CITY OF ALBUQUERQUE

July 8, 2021

Re: OSH MONTANO ROAD
333 Montano Road NW
Traffic Circulation Layout
Engineer's/Architect's Stamp None Provided (F14-D023)

Sheet Title
TRAFFIC CIRCULATION LAYOUT
Scale: As indicated
Drawn: JED
Project No.: 064559810
Sheet No.: **C201**

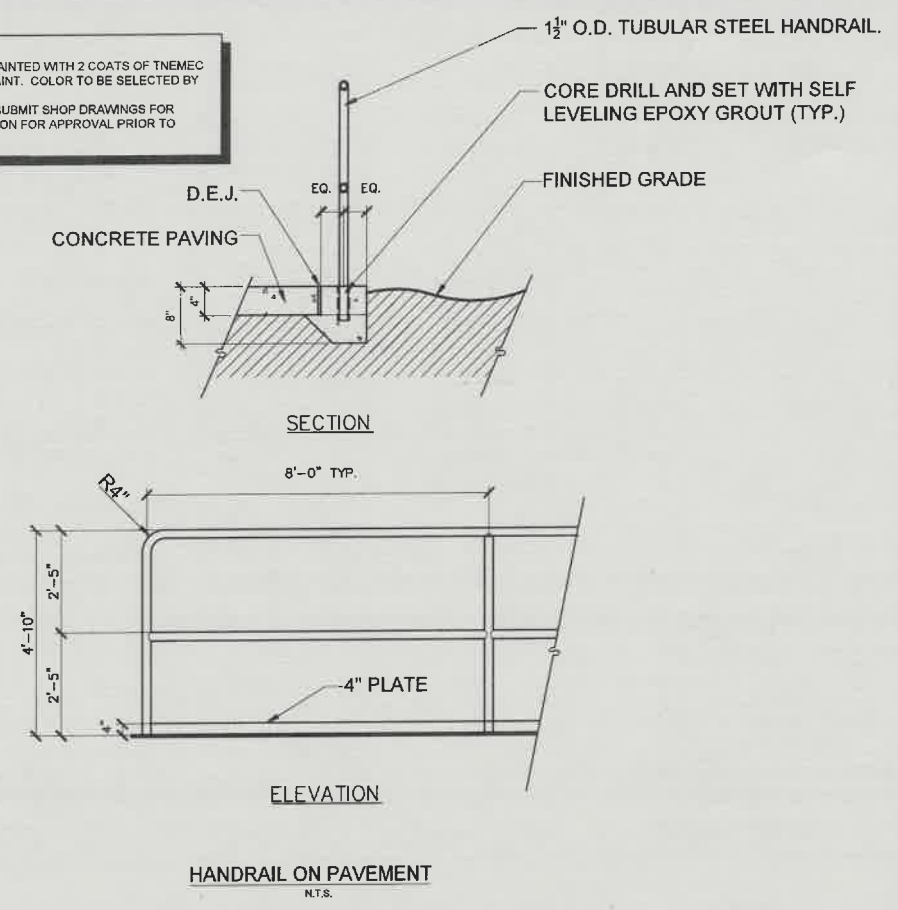
2. **Sheet C201 (Montano Road shaded area):**

- **Shown is a shaded area (5ft x 13.4 ft)** on Montano Road labeled as asphalt pavement work. You will need a Work Order (**DRC**) for this type of work within COA ROW. **Contact Curtis Cherne at 505-924-3993 (email: CCCherne@cabq.gov).** A asphalt pavement design will be required for proposed pavement work. **Montano Road NW is classified as a Principal Arterial and the pavement design will need to reflect this Arterial type pavement with R-value => than 50. See DPM for design requirements.**
- Label concrete work for sidewalk per COA std dwg 2430 and/or reference sheet C203 with a note on sheet C201.

3. Proposed asphalt pavement design on site needs to be provided for the shaded area shown on sheet C201 adjacent and on ADA parking stalls..
4. Sheet C201:

- Keyed Note 2: You have referencing Architect Plans for ADA parking stall signage. But no such sheet has been provide for our review. Please reference sheet C203 for this signage.

- Keyed Note 6: Reference sheet C203 for detail provided.
 - Keyed Note 5: Reference sheet C203 for ADA ramp detail.
 - Reference sheet C203 for ADA pavement symbol.

C203

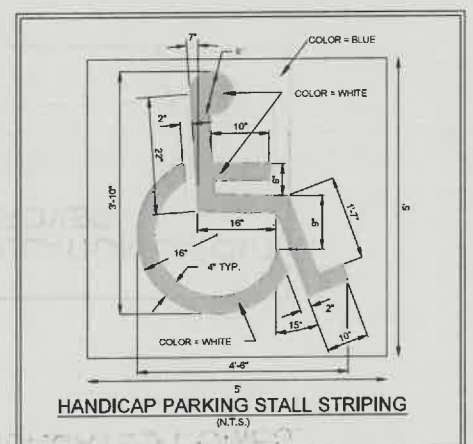
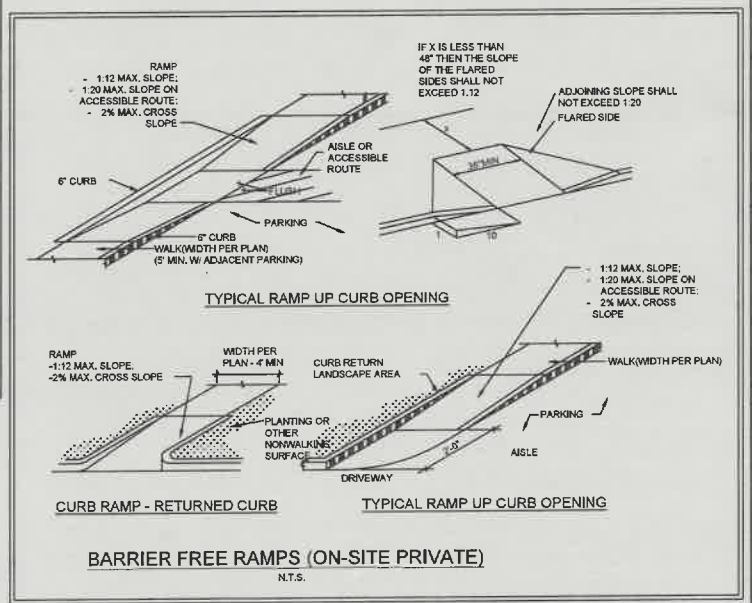
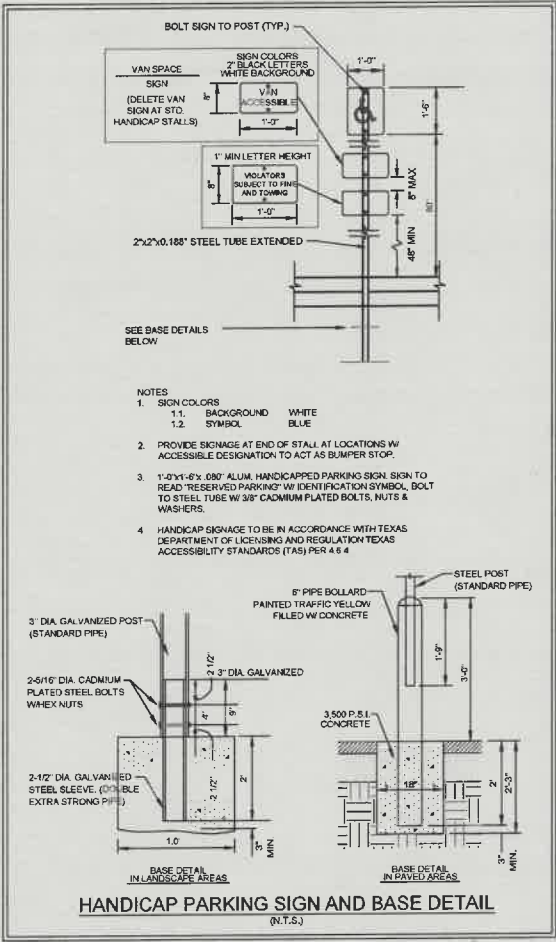
5. **Proposed Handrail:** Explain why you are proposing a handrail? Provide detail and rise/run segments with grades. **Both sides of pathway must contain handrail not just one side (Follow ADA STANDARDS for Accessible Design manual).**
